1/6/2025

David Gutierrez, PE
Albuquerque Bernillo County
Water Utility Authority

Re: ***2nd Review - PR-2024-009956 Taco Bell
Comment Responses to Utility Development Review***

## LAYOUT AND MATERIALS PLAN

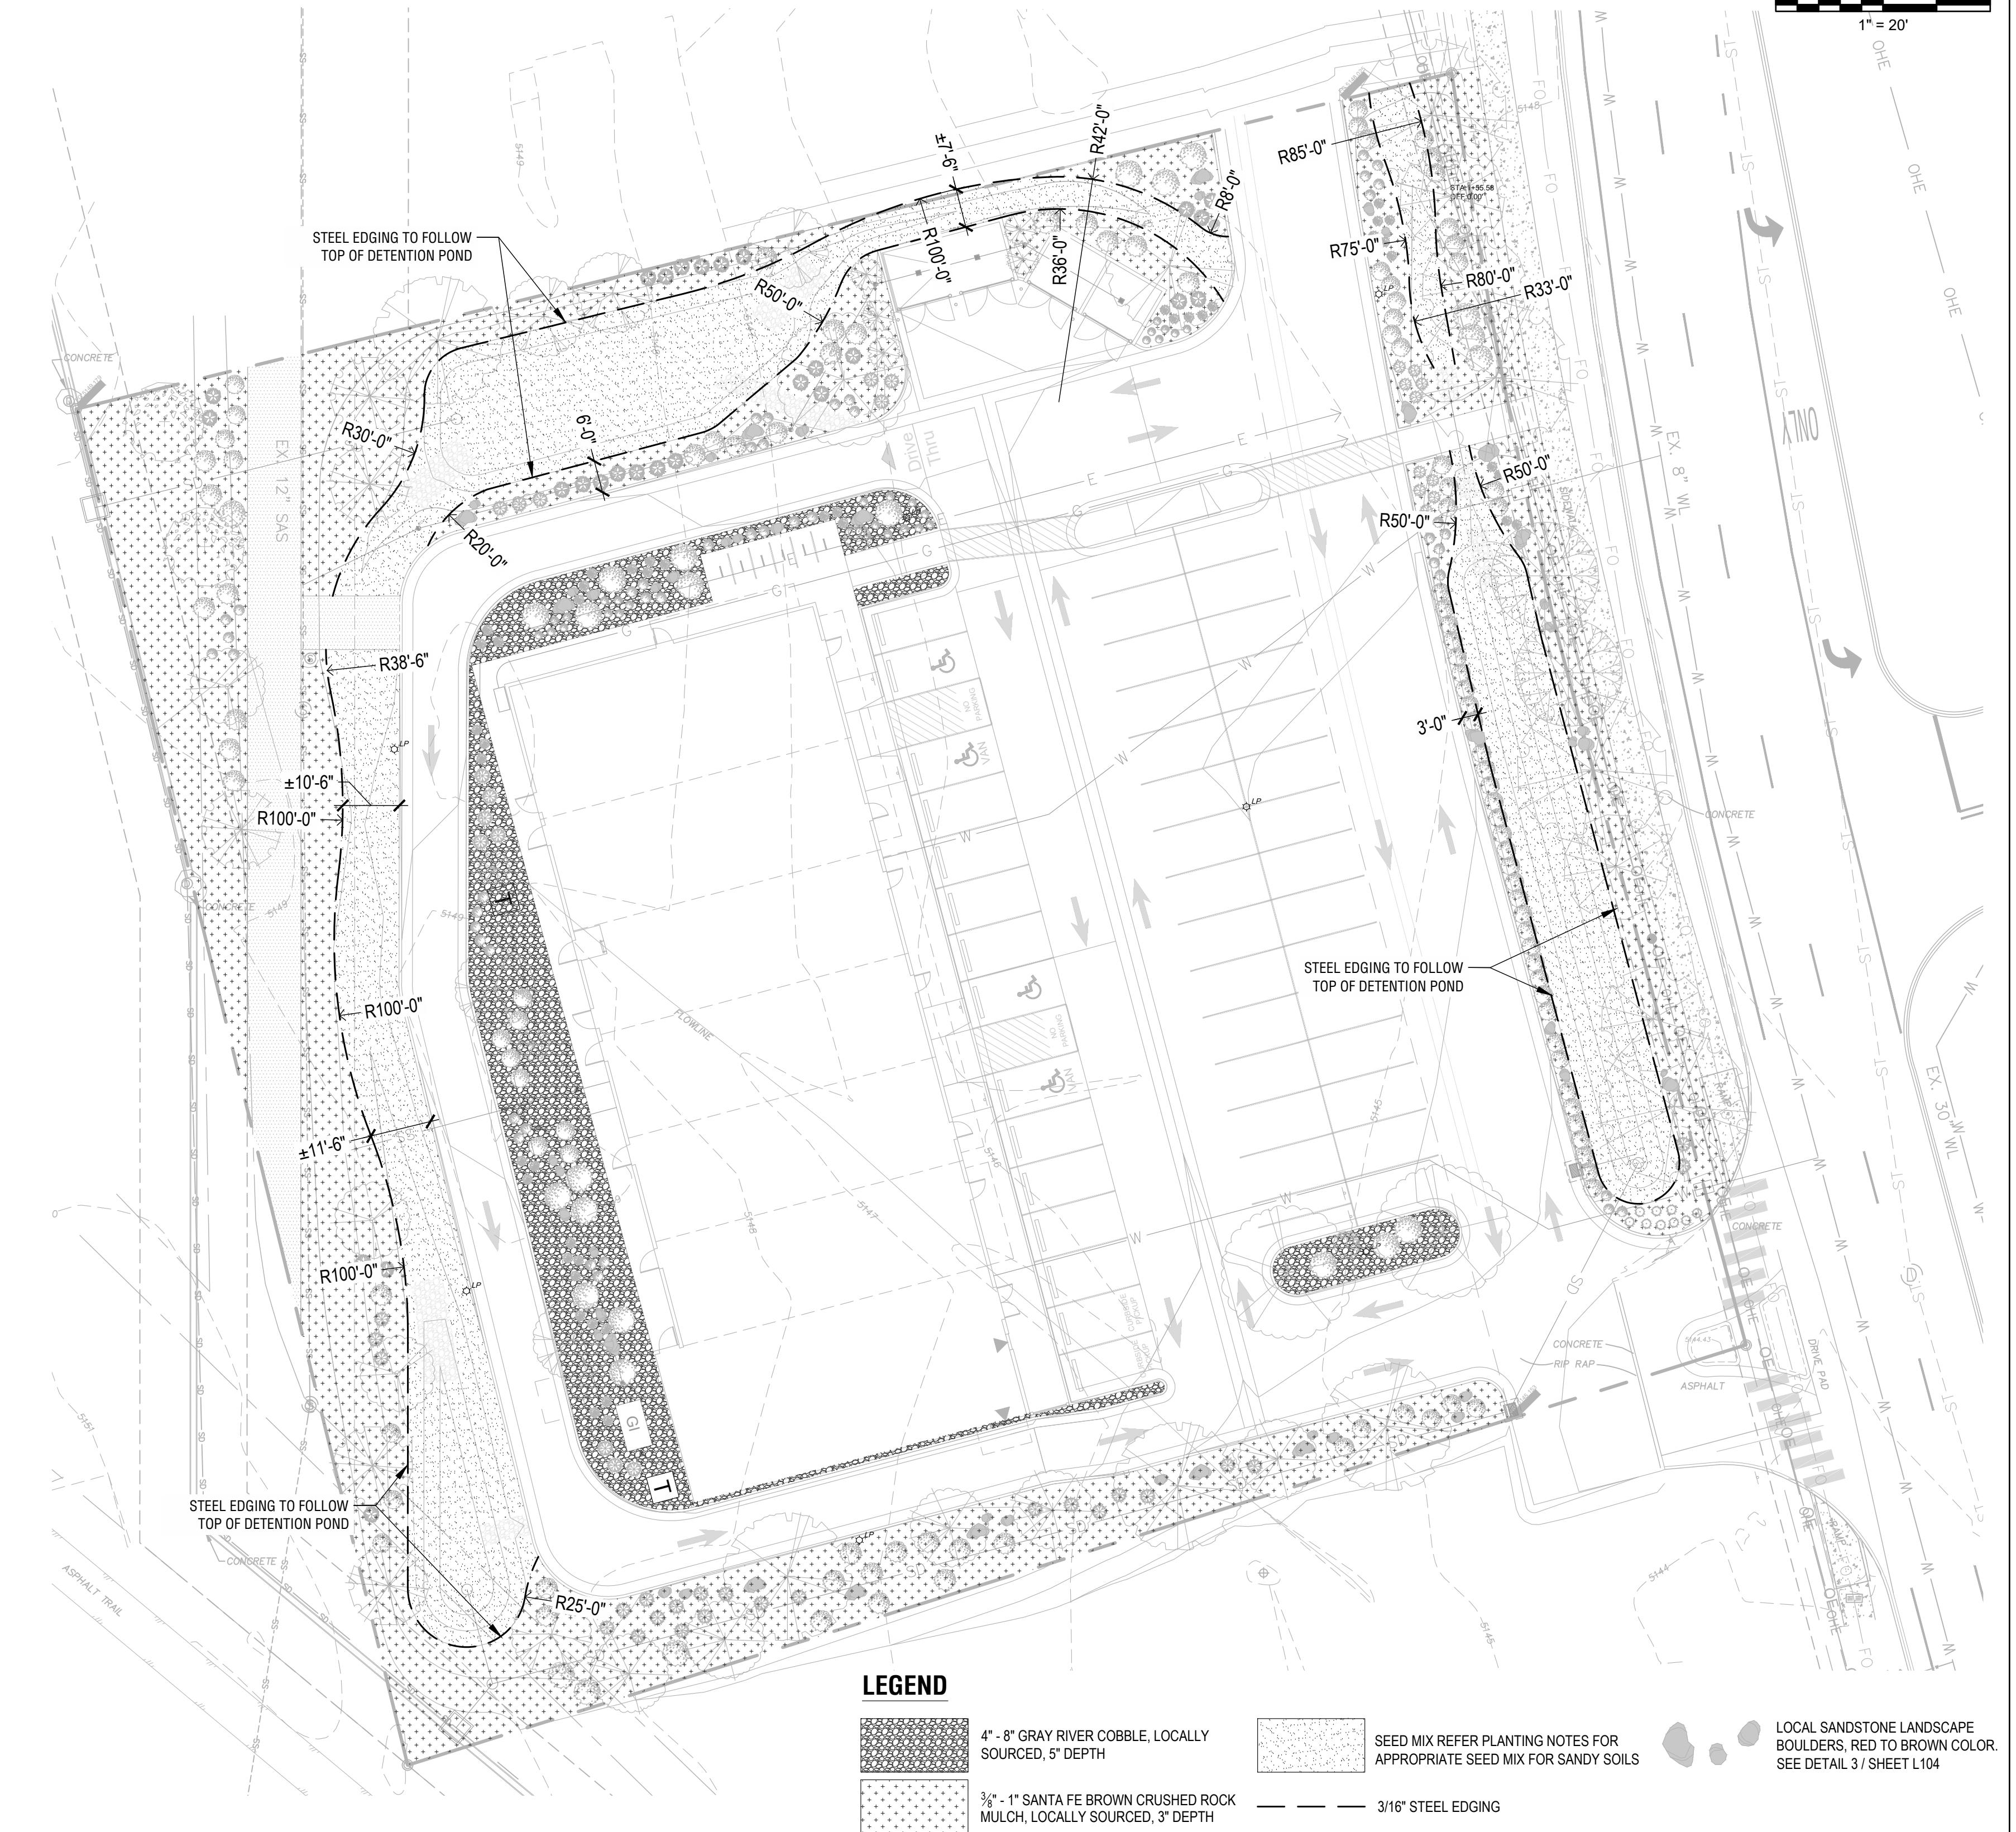
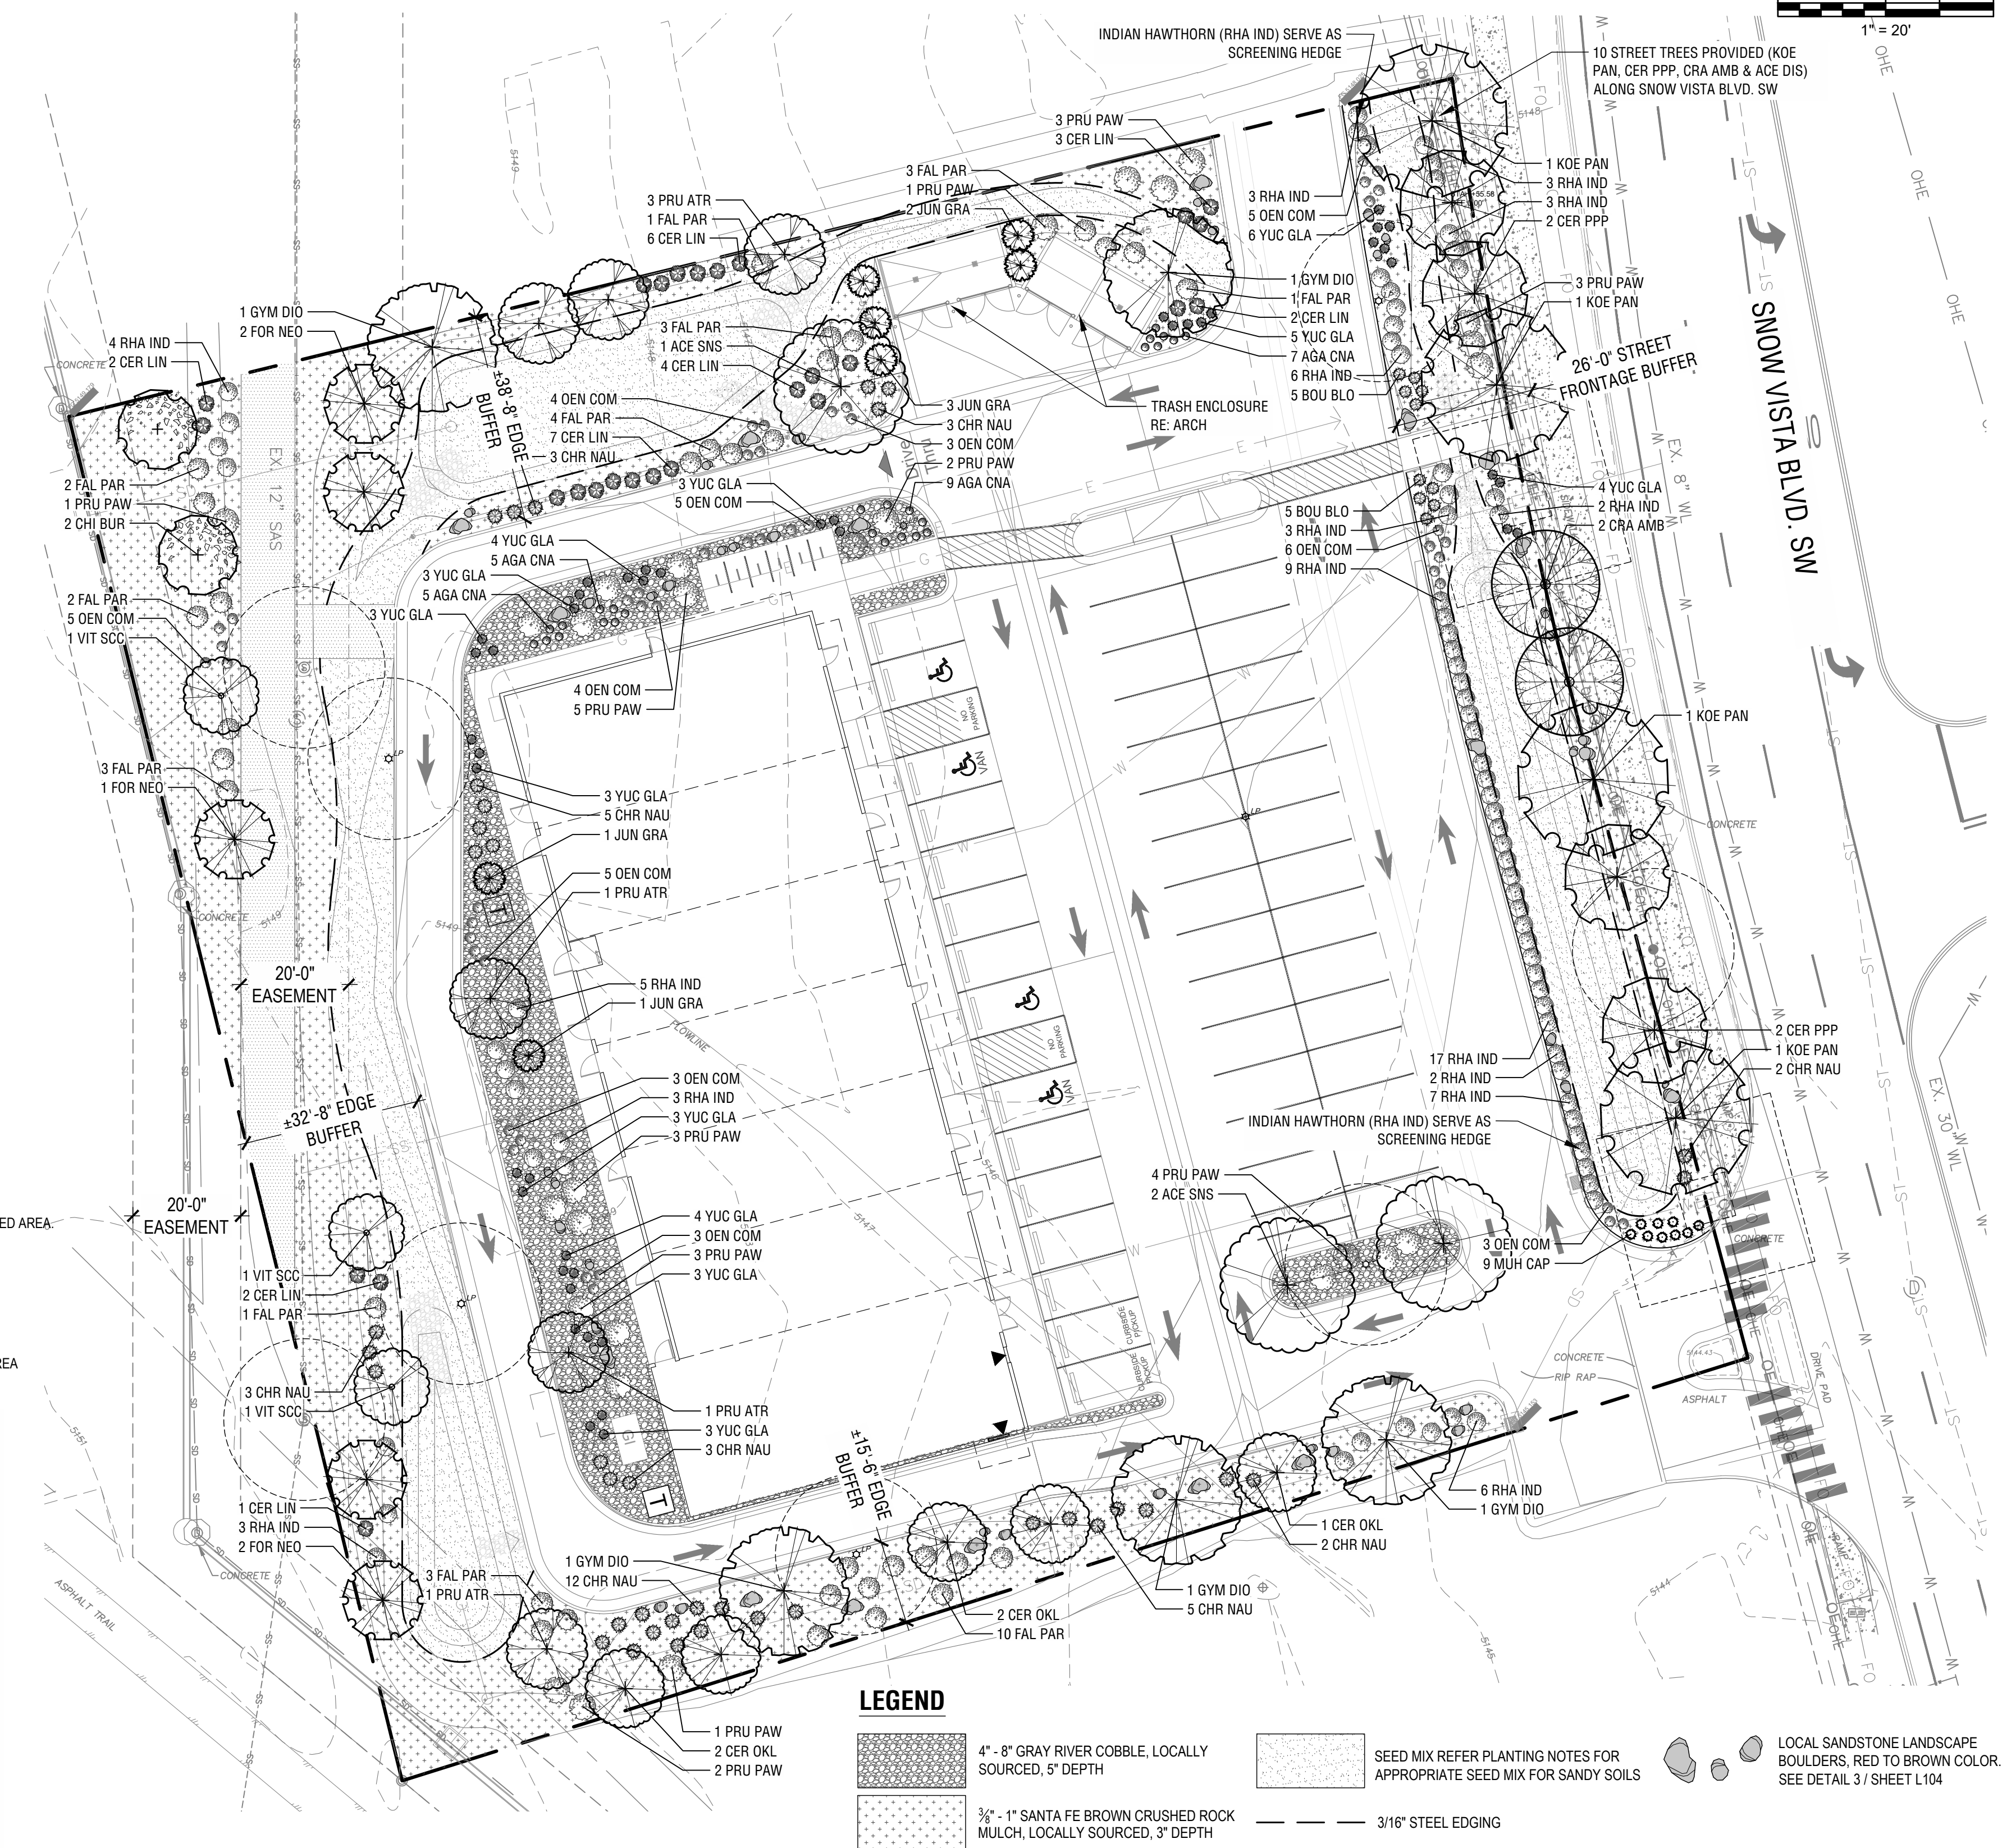
- **Response: Acknowledged.**
- g. There shall be no trees, parallel fences/sidewalks/curbs, or structures within the public water and public sewer easement. Please revise accordingly.

- **Response: The landscape plans have been revised so that trees, fences, sidewalks, curbs or structures do not encroach the public sewer easement.**
